Our Ref : S076158.015

File No : MP10\_0104

**RE West Circular Quay Public Domain Upgrade Works, Circular Quay /  
The Rocks (MP10\_0104)**

The City has reviewed the Environmental Assessment and notes the conceptual nature of the proposal. The City generally supports the design concept but cannot give its full support to the proposal in its current form due to the lack of design resolution and detail relating to some key aspects of the proposal.

OPT SECURITY

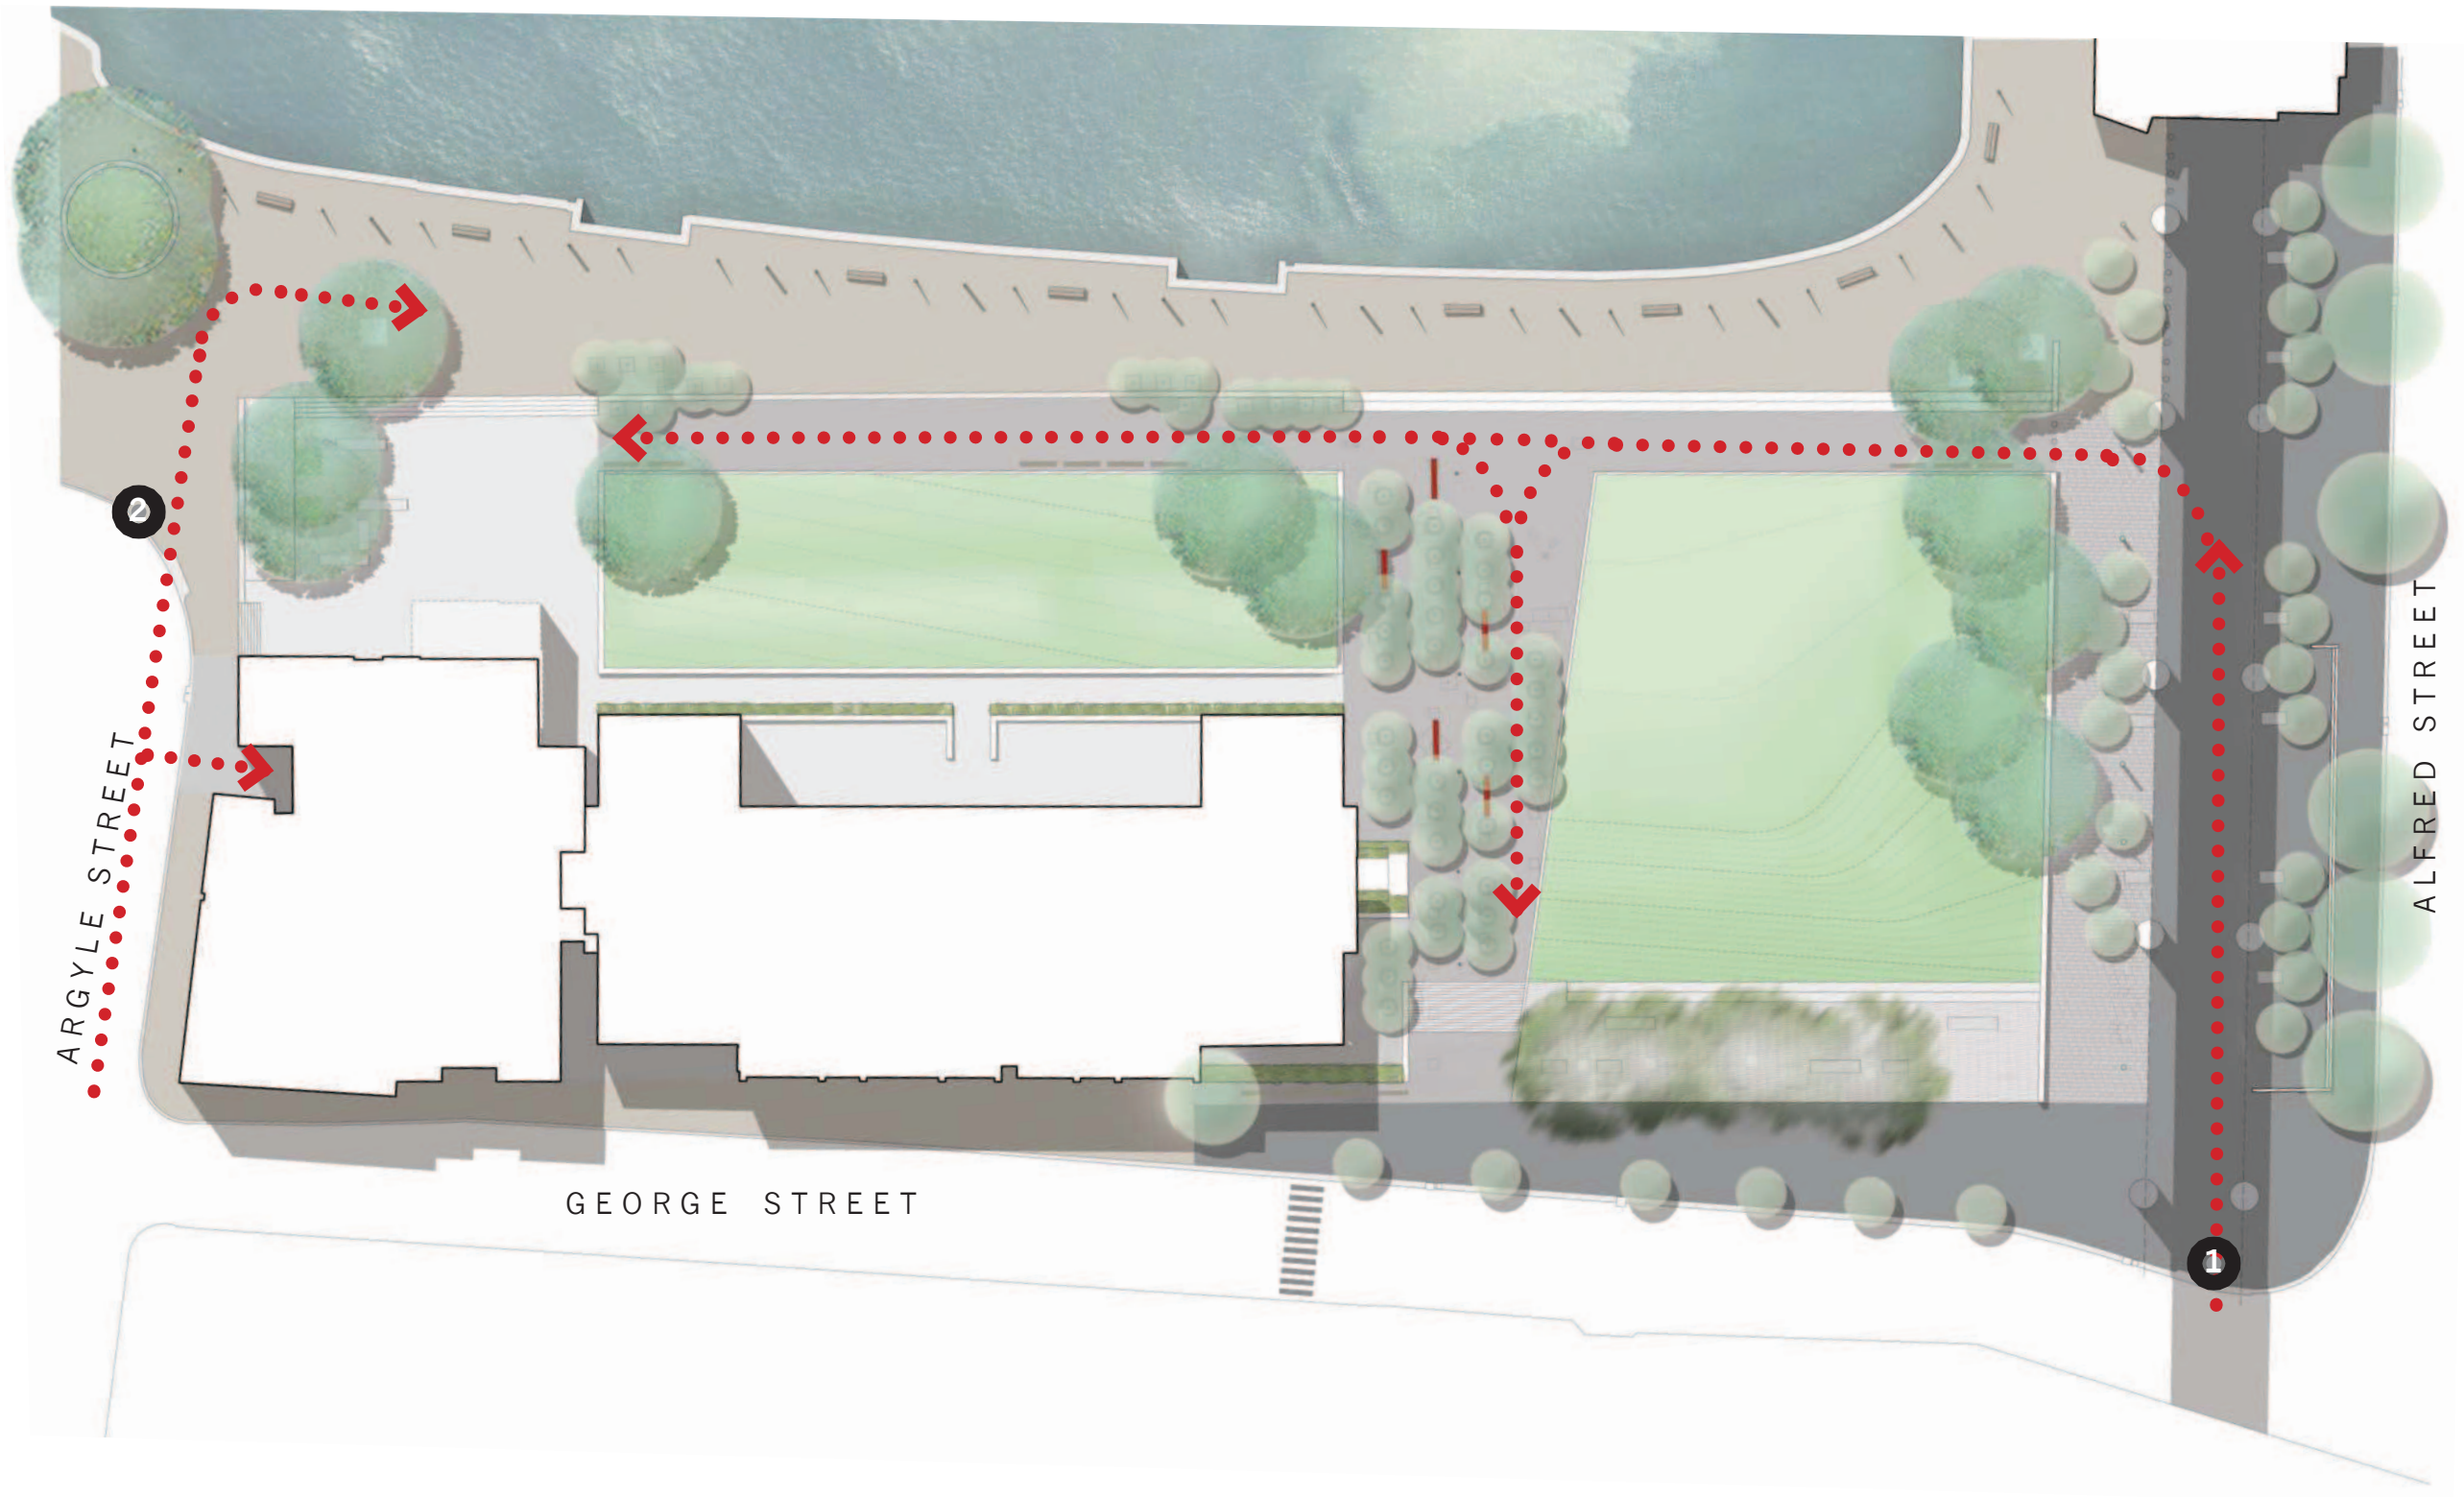
- a. There insufficient detail provided about the two 6m high sewer vents. These should be deleted and relocated away from the public domain.
